PROJECT NAME: 52 Federal Street - Re-build

PROJECT ADDRESS: 52 Federal Street CHART/BLOCK/LOT: 20 D 8

The proposal, dated 9-13-11 and revised 10-10-11, by Liv Chase at 52 Federal Street to rebuild the three unit structure that was damaged by fire and to convert the first level for parking with two 9 foot wide garage doors is approved with the following conditions of approval:

FRONT ELEVATION
SCALE: 1/4" = 1'-0"

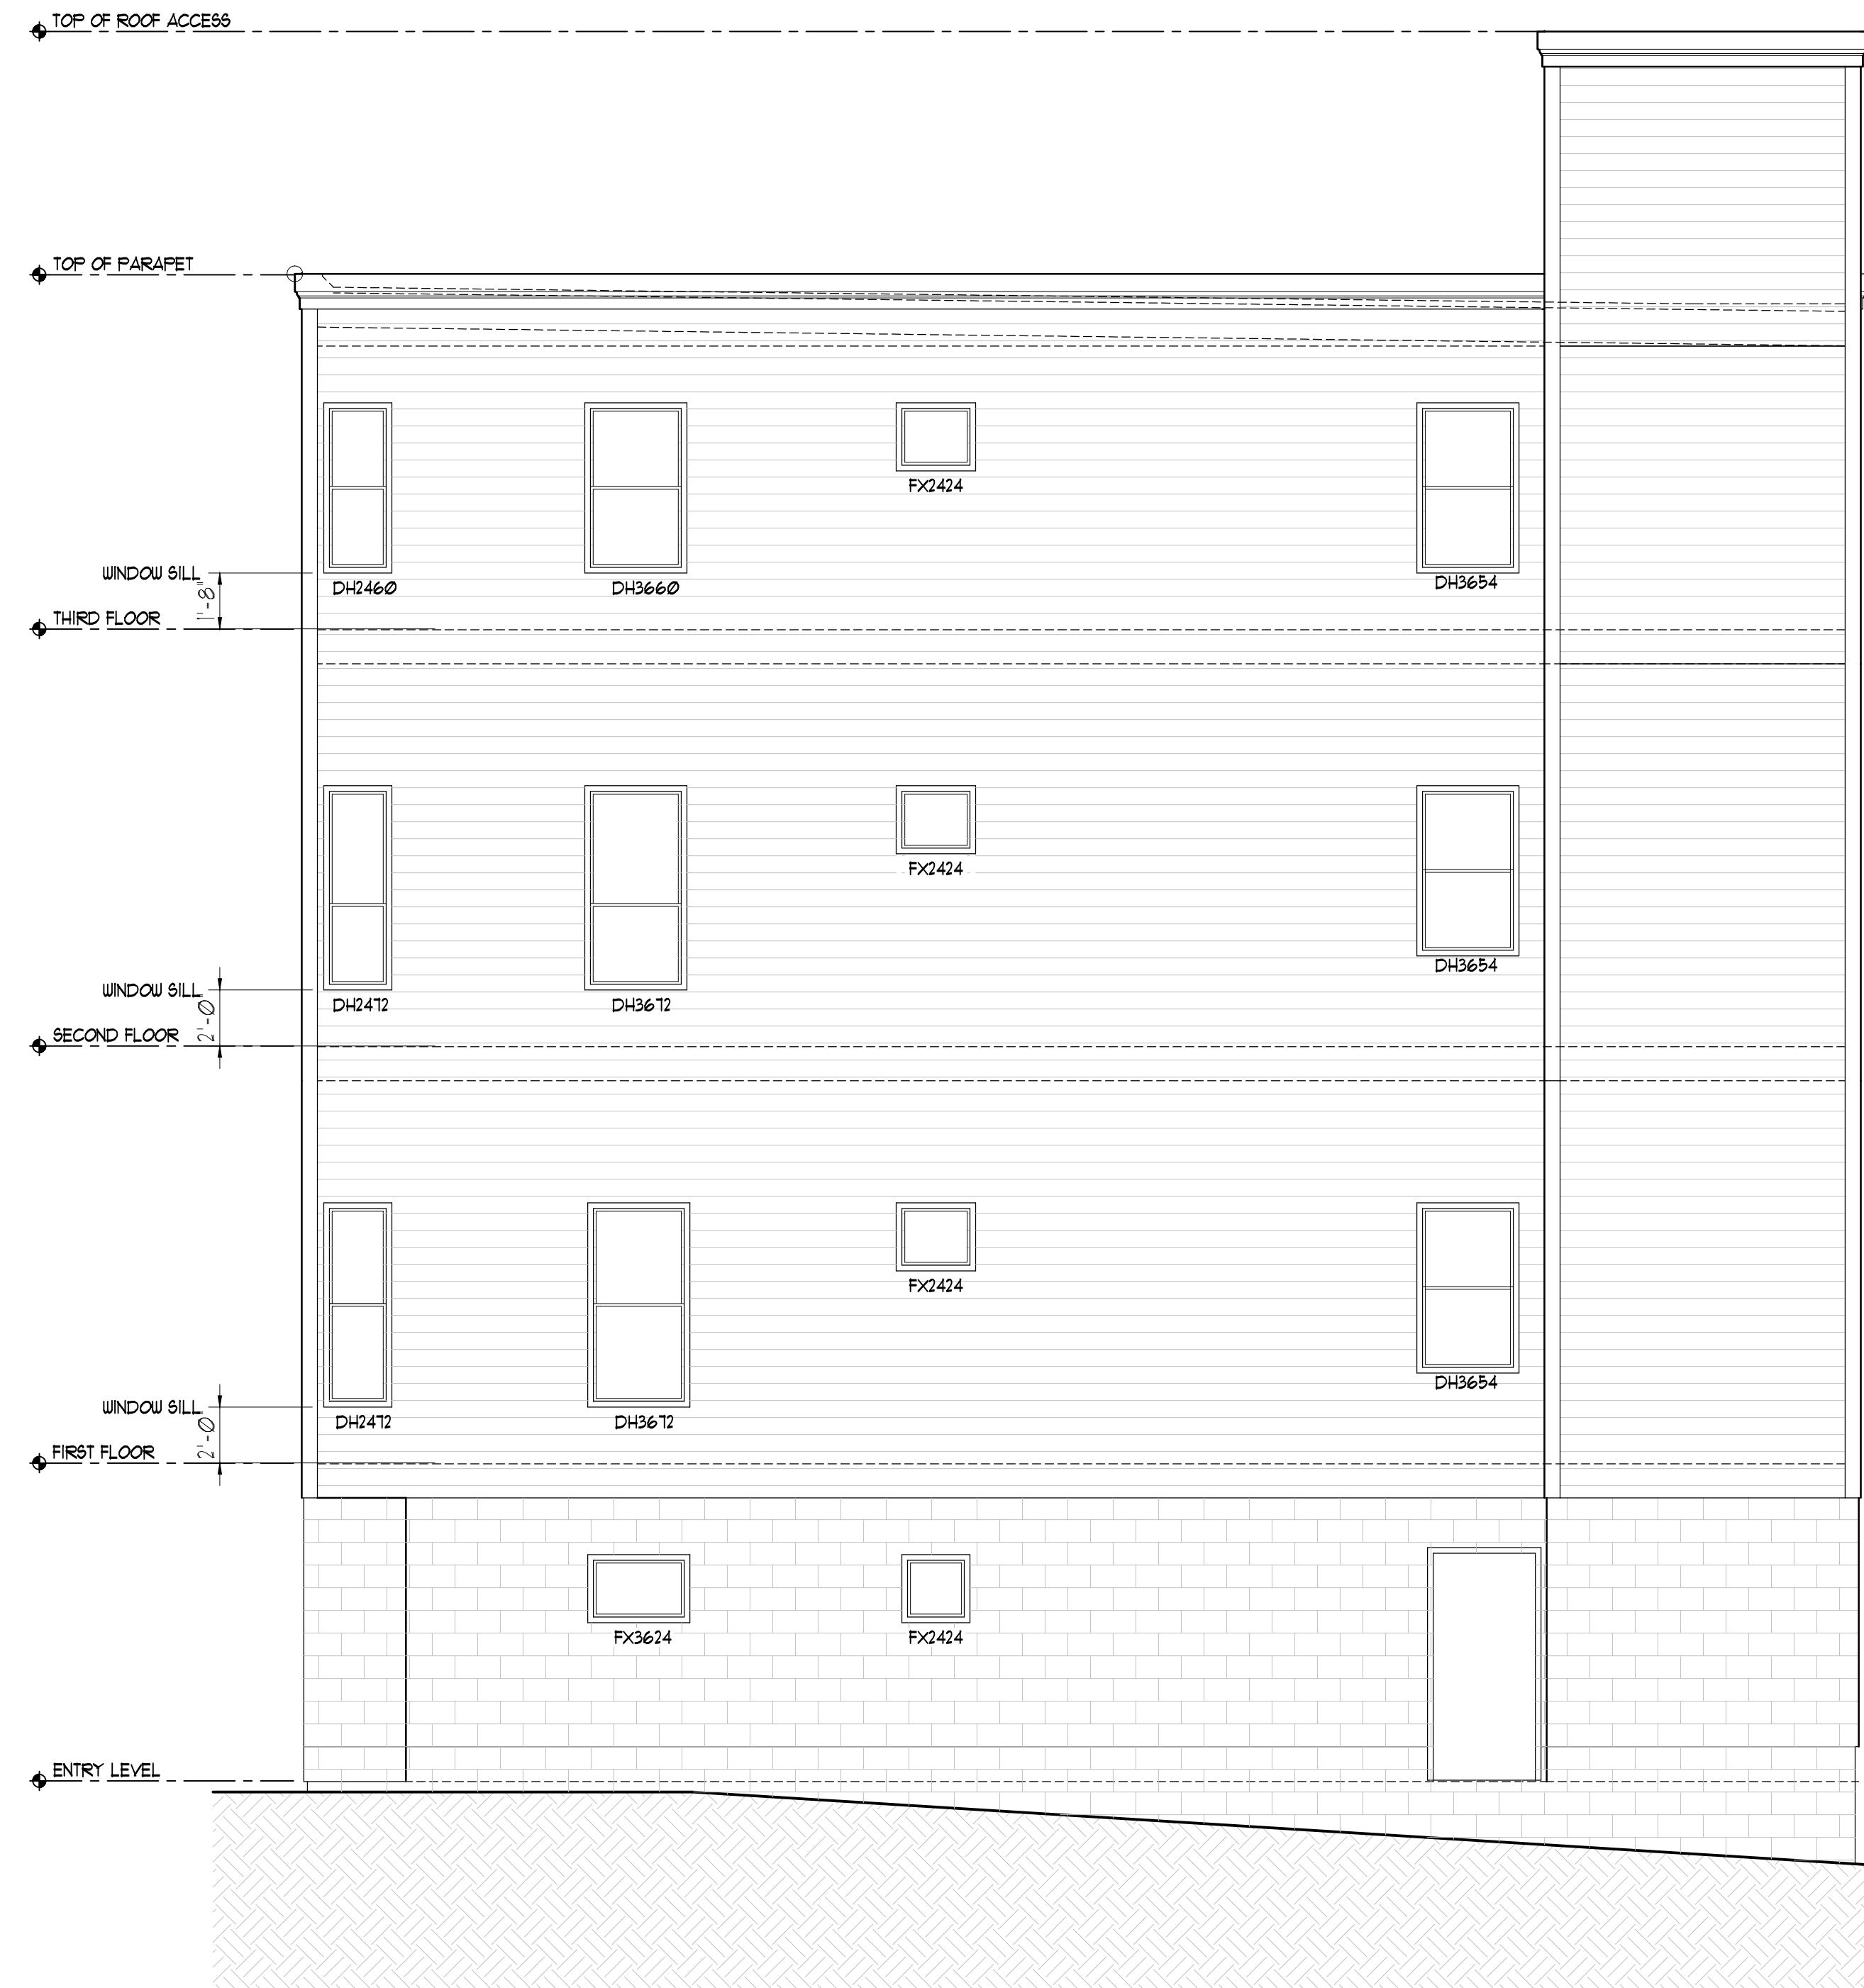
The two curb cut design is not acceptable. The Technical standards recommend one entrance for smaller projects and requires a separation of 20 feet between driveways. This design does not meet the criteria and it cannot be approved. In looking at the first floor drawing, it appears that you could have one common entrance or curb cut and vehicles could be parked on an angle within the structure.

In general we encourage developers to bring the pedestrian doorway entrance forward (rather than setback as depicted on your plans) and instead, recess the vehicle door in order to provide a more prominent doorway and pedestrian accessible facade.

1. The technical standards call for one curb cut. We recommend that you consider one curb cut and garage entrance for both vehicles. Curb cuts are generally 12 feet with a maximum of 20 feet. Please be aware that the area in front of the doors is a sidewalk, so a vehicle is not allowed to park in that area. The two curb cut design is not acceptable.

- 1) The proposed curb cut shall be no more than 20 feet and shall meet the city technical standards for the construction of the sidewalk and curb cut. (Technical Manual 1.8 Sidewalks and Driveway Aprons, <http://www.portlandmaine.gov/planning/technicalmanual2010.pdf>)
- 2) The construction details for the curb cut and sidewalk shall be submitted within 30 days of this approval for review and approval by the Planning Authority and Department of Public Services.
- 3) Parking of vehicles is prohibited on sidewalks, so vehicles shall not be parked in front of the garage doors.
- 4) The applicant shall obtain all required City permits, including but not limited to building permits from the Inspection Division and street opening permits from the Department of Public Services.

I discussed your plans at today's development review meeting and I am ready to sign off on the two garage door openings with one 20 foot wide curb cut. The parking manager asked that I put in the decision that parking of vehicles on the sidewalk is prohibited, so you will not be able to park any vehicles within the apron to the garage.
